From: Christopher [REDACTED]
Sent: 12 July 2016 18:34
To: DevelopmentControl & DevelopmentManagement
Subject: Planning objection to application re 132 Park Grove
Attachments: deeds.pdf

I write in objection to the proposal to convert 132 Park Grove into a House of Multiple Occupancy. Whilst I understand that one should be open minded and tolerant of the changes which life can bring I do feel that if the development were to go ahead it would be in its own small way a loss of amenity to the community.

LAYOUT AS PROPOSED

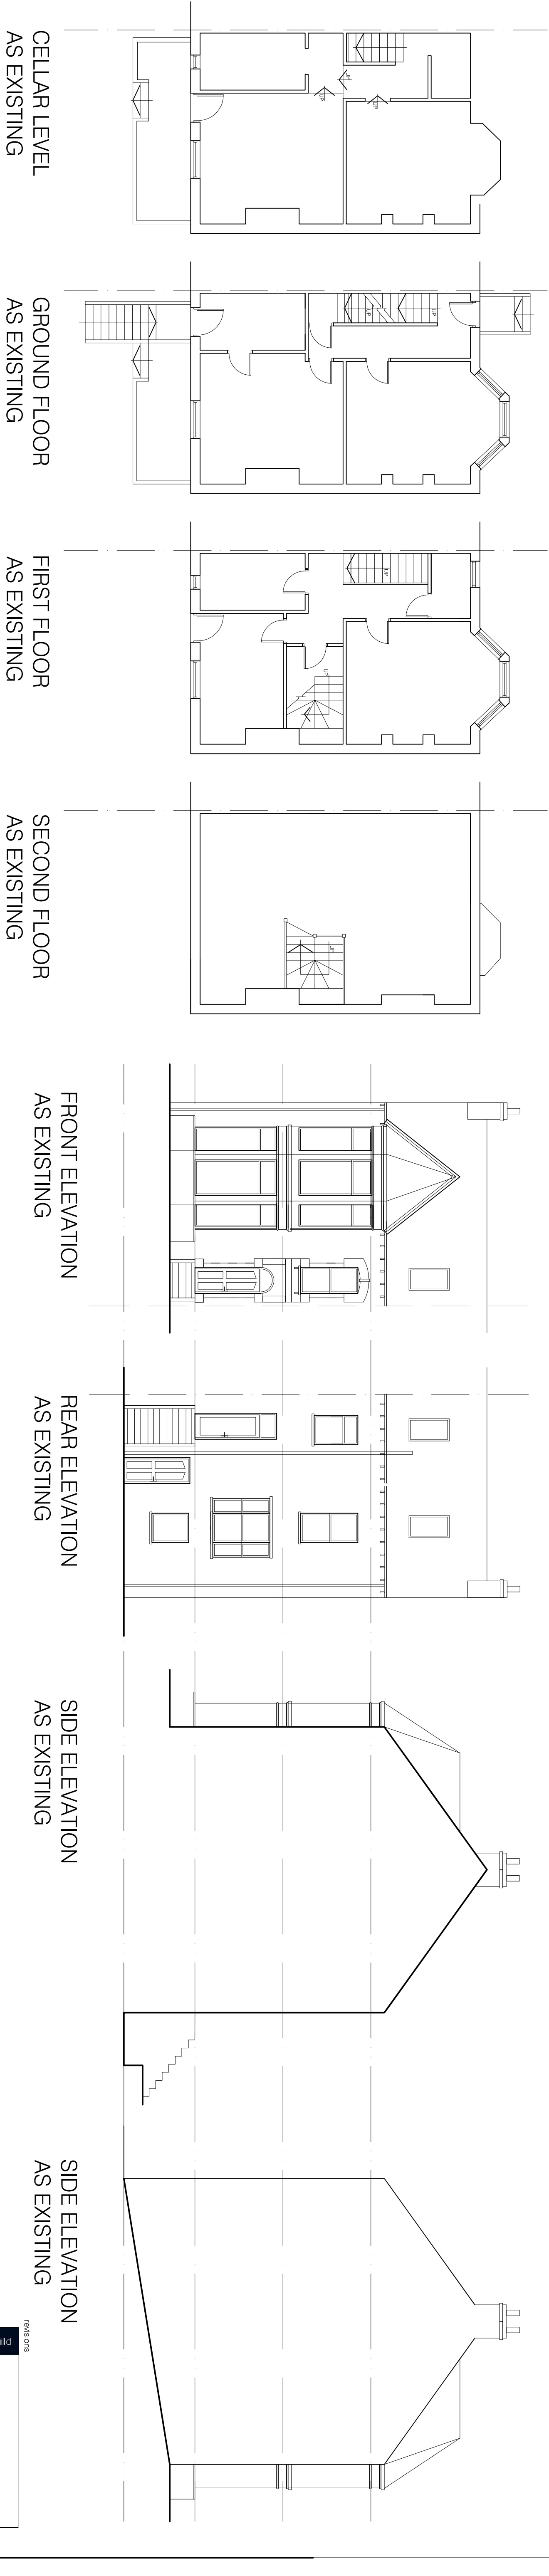
I note that there is a proposal to create a small stairwell in the front garden in order to access the cellar. "Similar designs are commonplace in the local." I have to say that I am unaware of any such designs anywhere else in Park Grove and must point out that such a change would be quite out of keeping with the architectural aesthetic of the terrace as it currently stands. Indeed I have been looking at the deeds for number 134 Park Grove and I note that the original vendor of the land applied a restrictive covenant to the sale of the building plots for these houses: "And all houses should be faced with dressed stone and no building except bay windows porticoes and other similar architectural features should be allowed to project beyond the building lines shown on the said plan." (See attached document) Clearly the construction of a stairwell in the front garden in front of the bay window would contravene the intentions of this covenant.

I also have concerns for the well being of the tenants of the self contained flat with its small floor area, low ceiling and lack of natural light; further the bathroom opening off the kitchen area would appear to me to be a rather unorthodox layout.
